Letter No: A2/19027/91

Sub: MMDA - Planning Permission -
Construction of residential building
in Plot No.95 and 96part at S.No. 260/1A1
part of Porur village - Approved - Reg.

The proposal received in the reference cited for the
construction of residential (Ground+First floor) building at
Plot No. 95 and 96part, S.No. 260/1A1 part of Porur village
has been examined and found approvable.

TER. PLAN

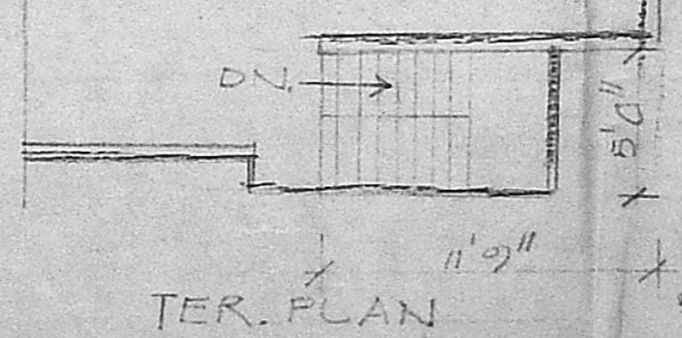
towards Regularisation charge by two separate Demand Drafts of
a Nationalised Bank in Madras City drawn in favour of the
Member-Secretary, MMDA, Madras-8 or ~~in cash~~ and pay at MMDA
office Cash Counter between 10.00 A.M. and 4.00 P.M. within
10 days and after remit the said amount, you are requested to
remit the duplicate receipt to Area Plans Unit. You are also
requested to submit the Affidavit for ULC in Rs.5/- Stamp paper
duly attested by Notary Public. Planning Permission application
will be returned unapproved if the amount are not paid within
the stipulated time. // and also you are requested to furnish 5
copies of revised plan showing the Terrace floor also.
